Our Ref: SE/CL/2015/38607/S

Application No: 14/02004/HYBRID (CDC) & 14/02063/OUT (WODC)
Site Address: Land South of Perdiswell Farm, Shipton Road,
Shipton On Cherwell, OX20 1QR
Proposal: **OUTLINE:** Up to 1,500 dwellings, including affordable housing and up to a 150 unit care village (C2) with associated publicly accessible ancillary facilities; site for a new primary school; up to 930sqm of retail space; up to 7,500sqm locally led employment (B1/B2/B8) including link and ride; site for a Football Association step 5 football facility with publicly accessible ancillary facilities; public open space; associated infrastructure, engineering and ancillary works, (all matters reserved except for means of access to the development); and **FULL:** development of Phase 1 at the south western corner of the site for the erection of 29 residential dwellings (29 of the 1,500 described above) with associated open space, parking and landscaping; with vehicular access provided from Upper Campsfield Road (A4095), Shipton Road and Oxford Road (A44).

This being the case, **Sport England objects to the proposal** the subject of this application.

Land use Parameter Plan

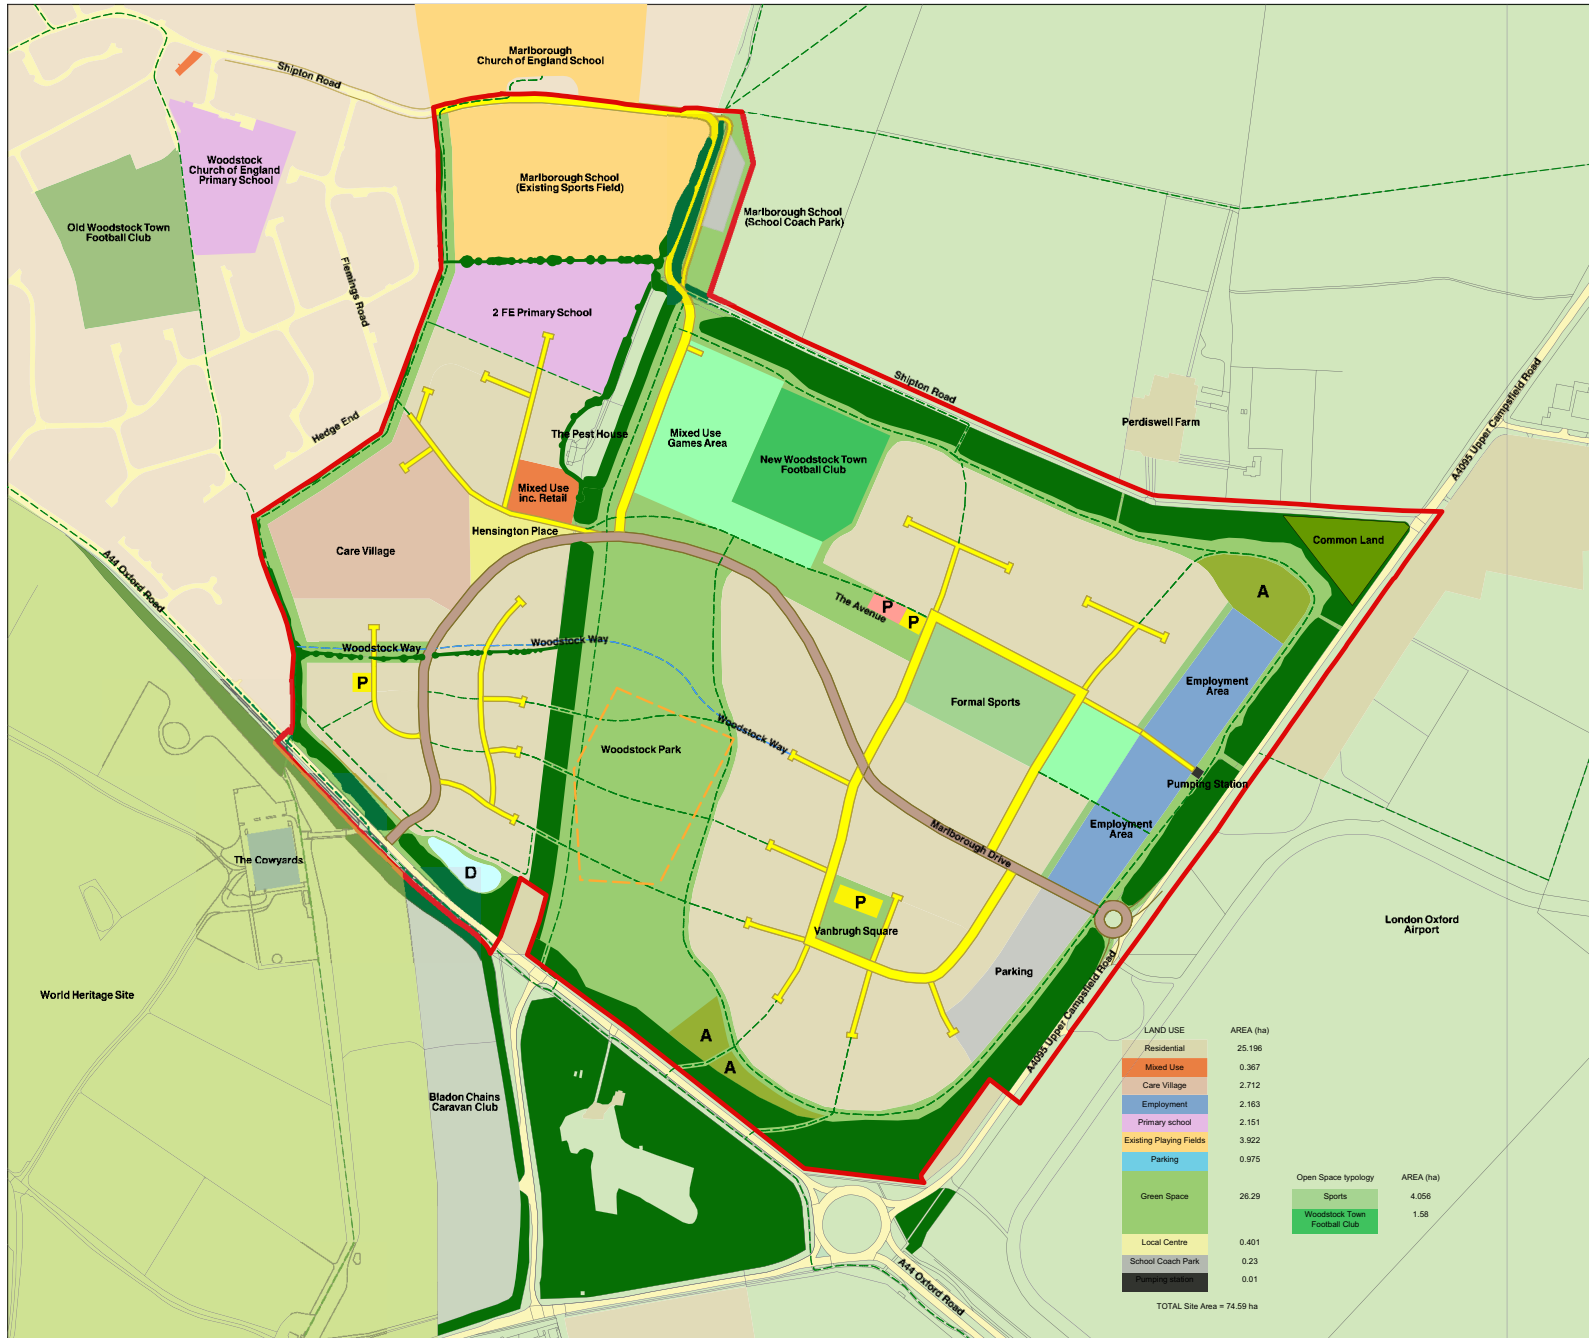
While the Land Use Parameter Plan (drawing numbered P300) and Illustrative Layout plan (drawing numbered SK027) indicate the location of a proposed football ground with two pitches, in the northern part of the site, the Landscape Strategy (Design and Access Statement pages 80 & 81) is likely to preclude the provision of any other playing pitches, a MUGA or a skate park on this part of the site.

1. Submit a revised location plan which excludes the existing school playing field from the northern part of the application site.
2. Provide a clear explanation for the number and type of playing pitches to be provided to meet the needs of residents of the proposed development.
3. Provide a plan to demonstrate how the proposed pitches and other outdoor sporting facilities can be accommodated on the site in addition to the proposed football ground.
4. Clarify when the proposed sports facilities will be provided in relation to a specific phase or phases of the development.
5. Identify specific leisure centre improvements intended to benefit from the s.106 contributions.
